Our Ref: R/243/11/
Your Ref:

The Town and Country Planning Act 1990 (as amended)
Town and Country Planning Development Management Procedure Order 2010 (as amended)

Proposed renovations & additions
Herne Farm House 2 Park Drive Rustington

PROPOSED ELEVATIONS 1:50

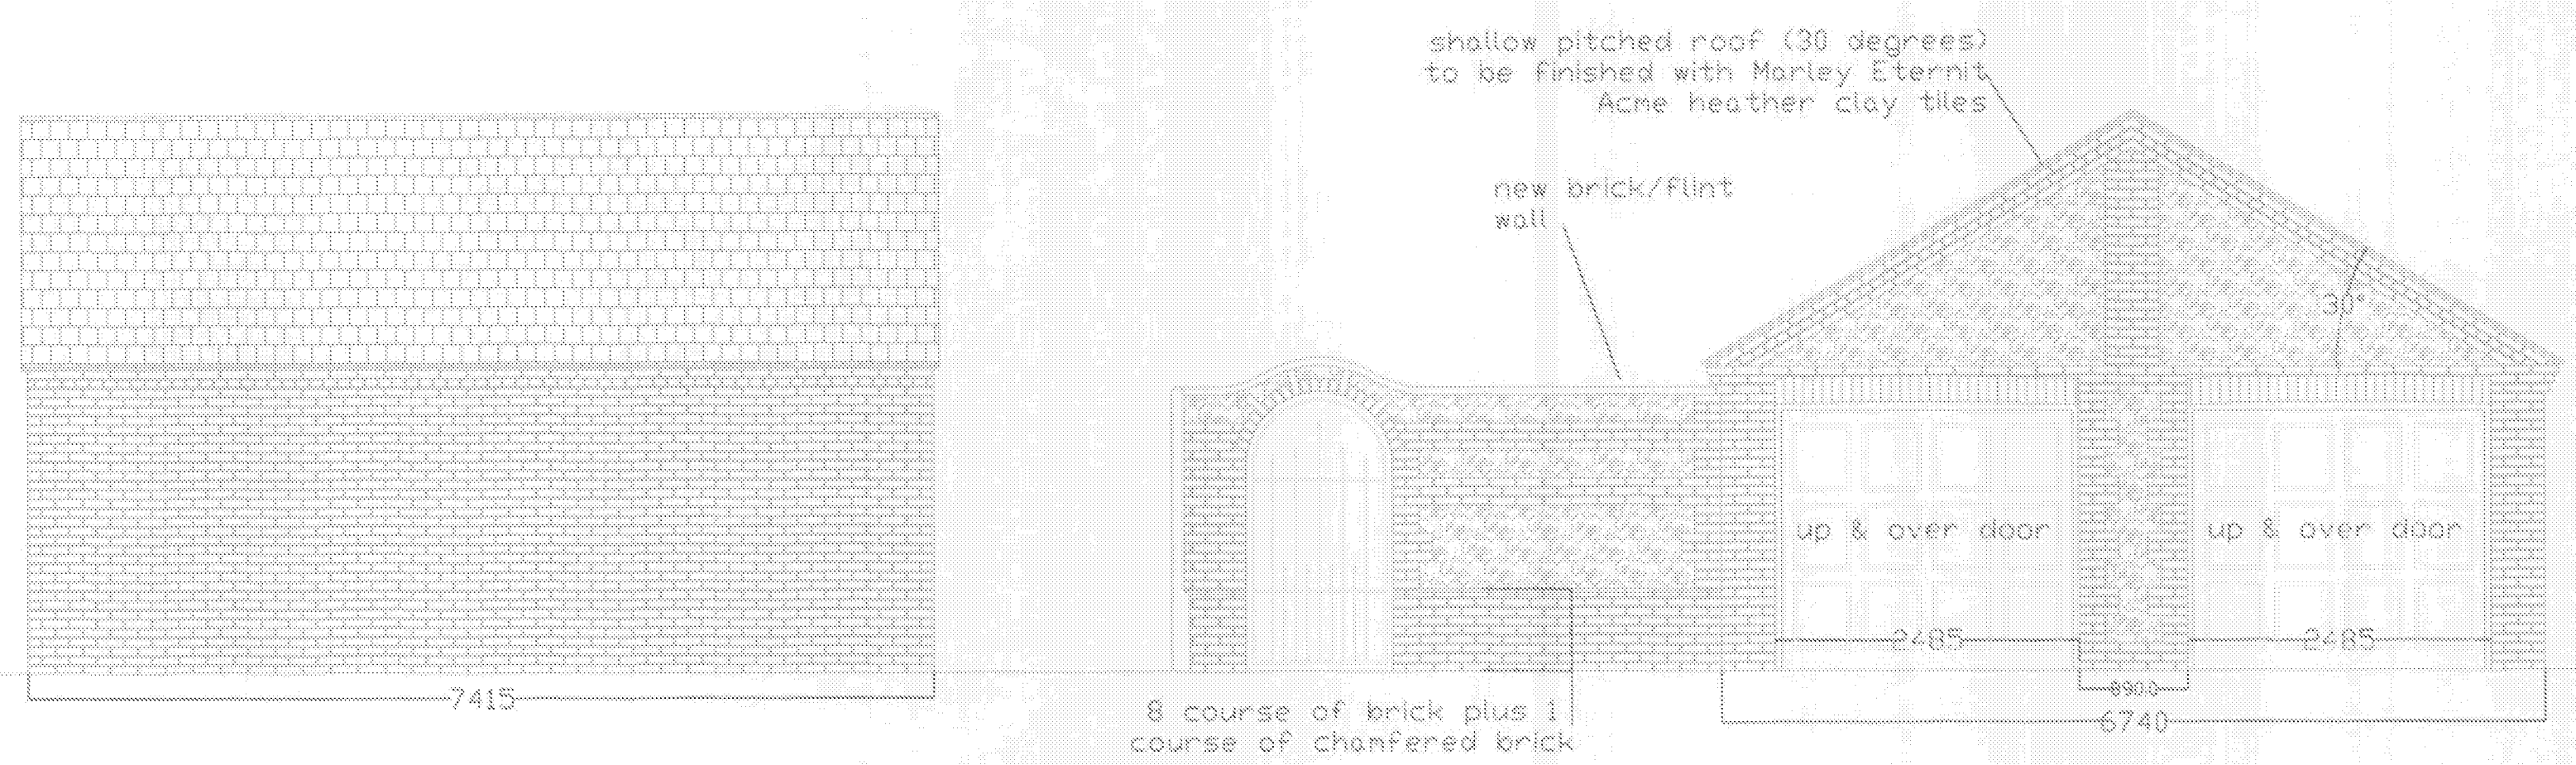
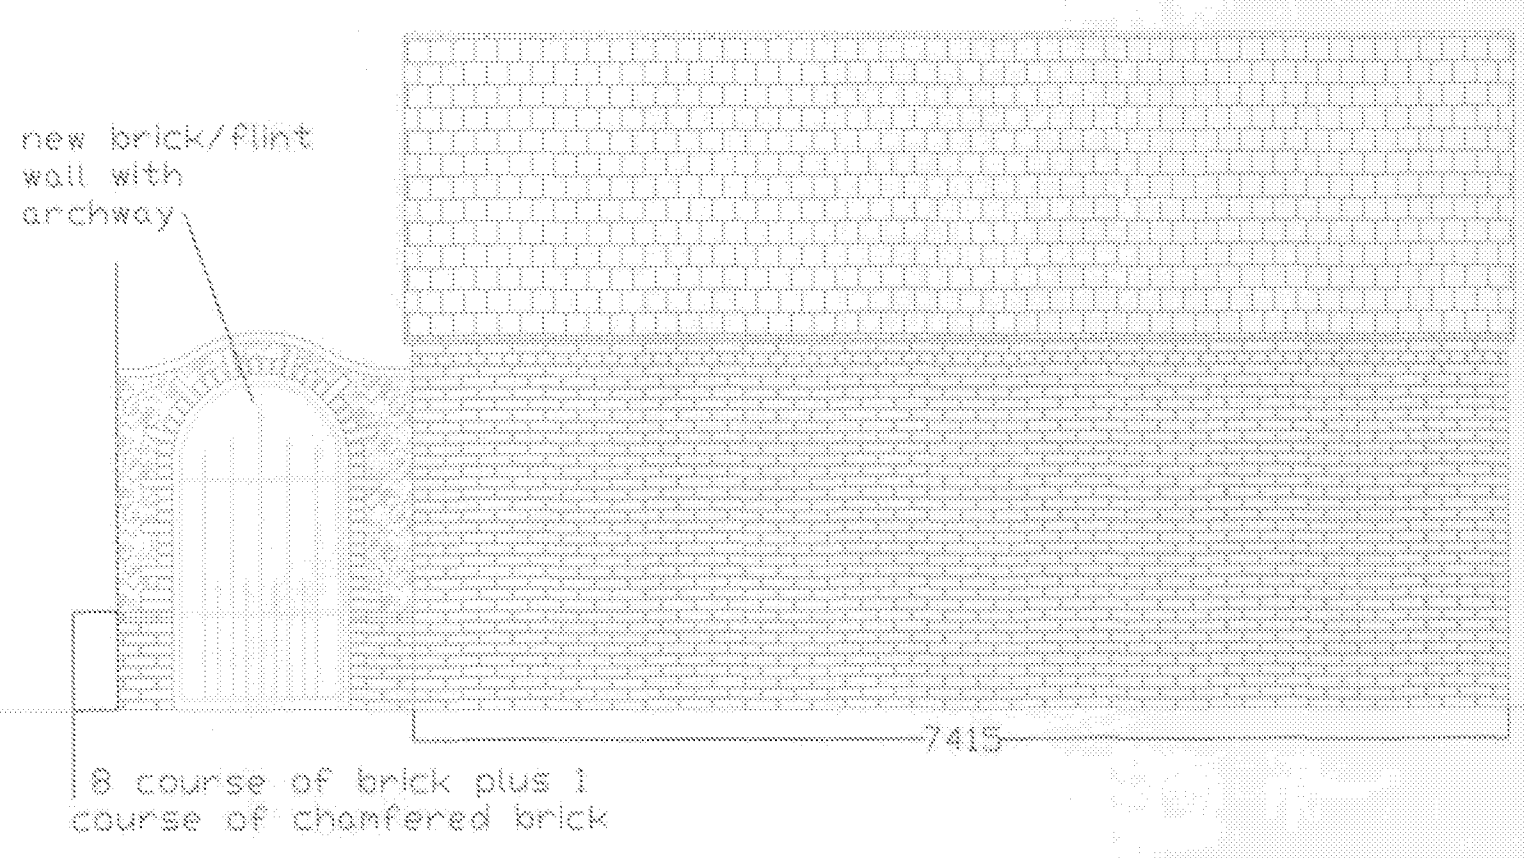
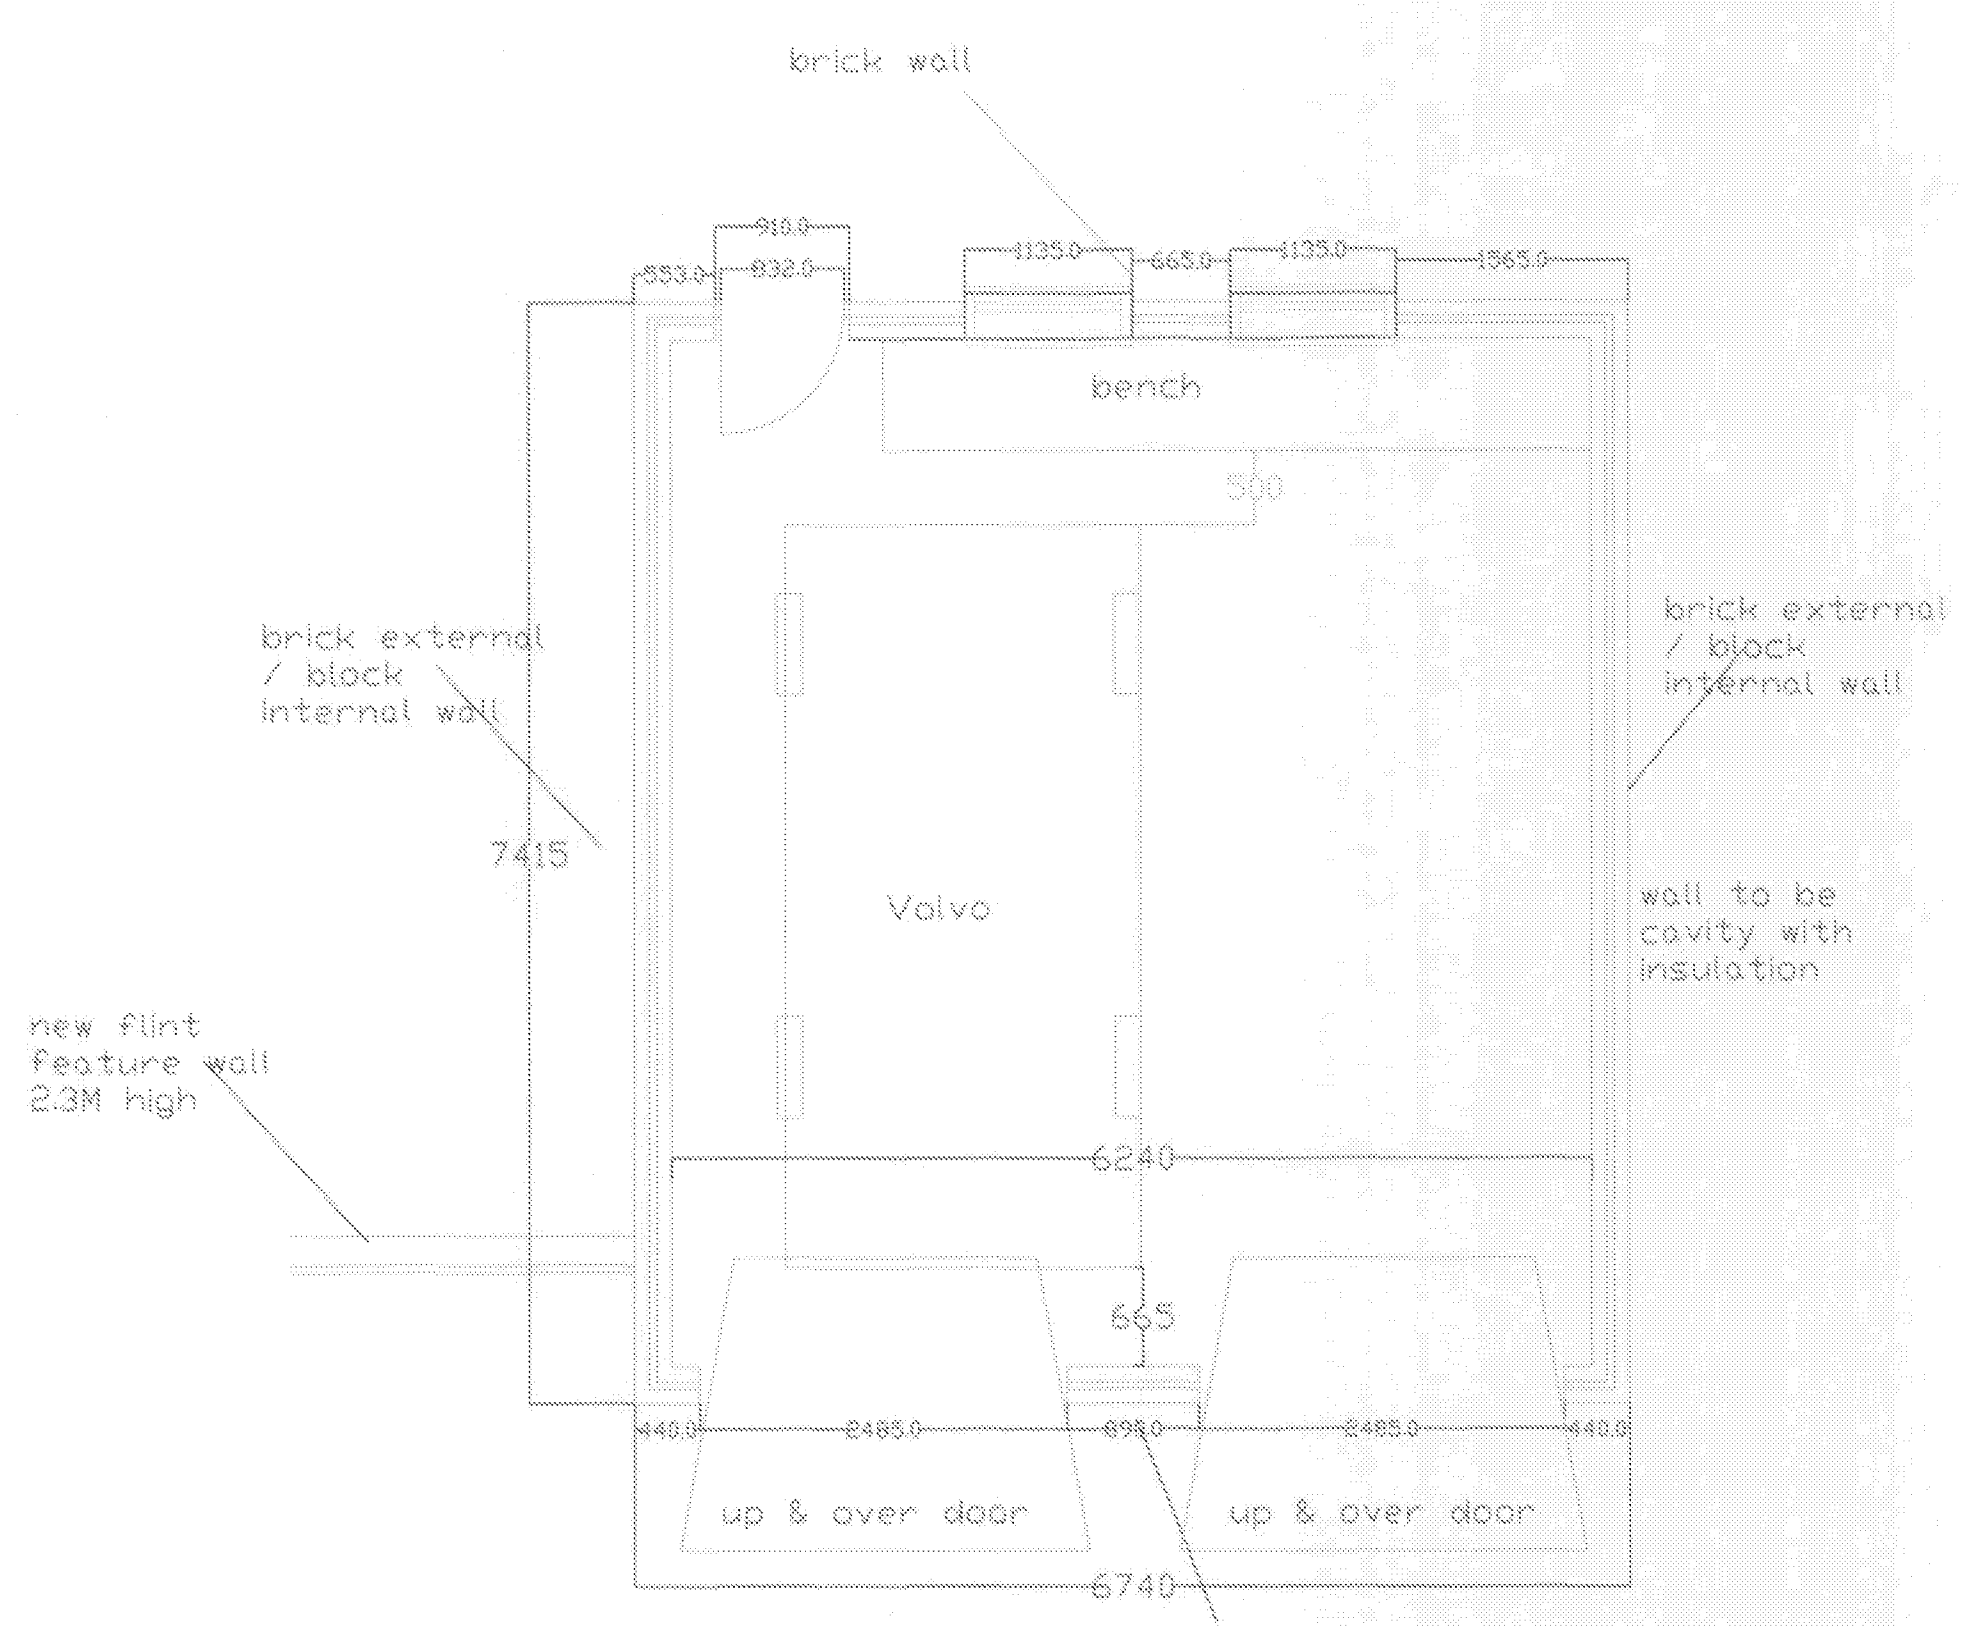
Please provide 1 electronic or 3 paper copies of proposed east and west elevations of the main dwelling to show the proposed connecting wall to the garage and a revised proposed side elevation of the garage. The archway shown does not accord with the floor plan and site plan

R/243/11

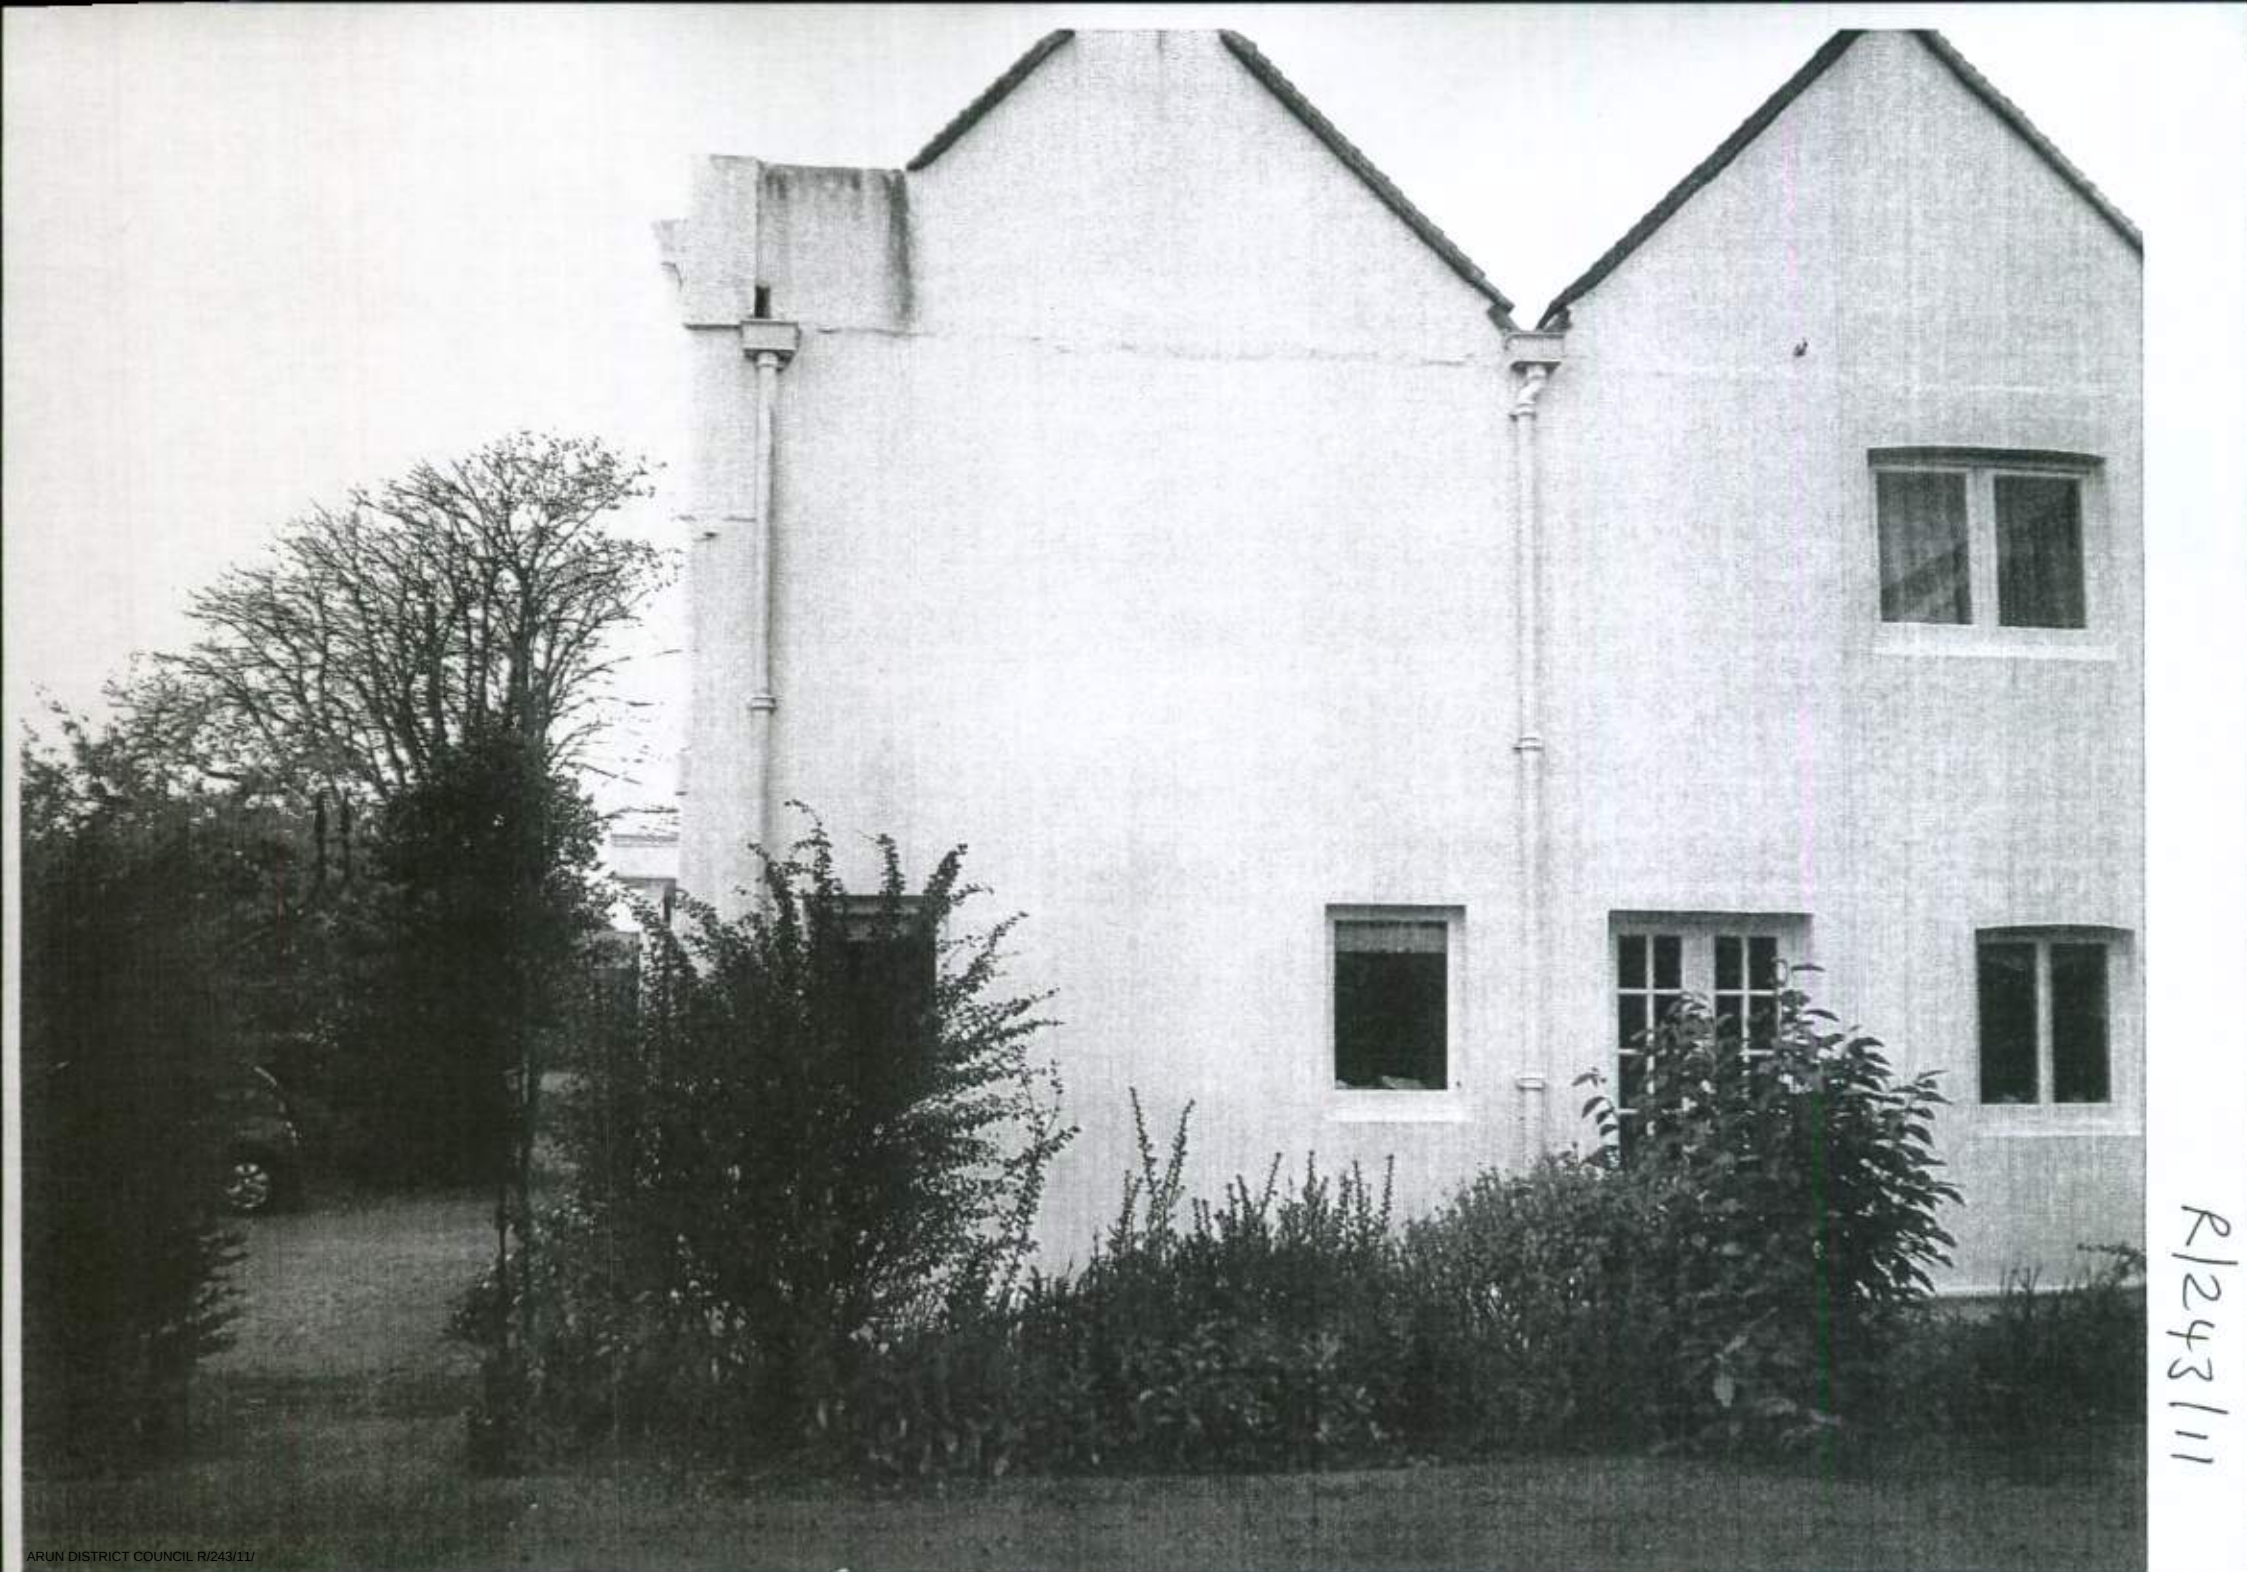
I require 1 electronic or 3 paper copies of a revised location plan showing a continuous red edge around the application site in accordance with the guidance notes available on our website detailed below (click on National List).
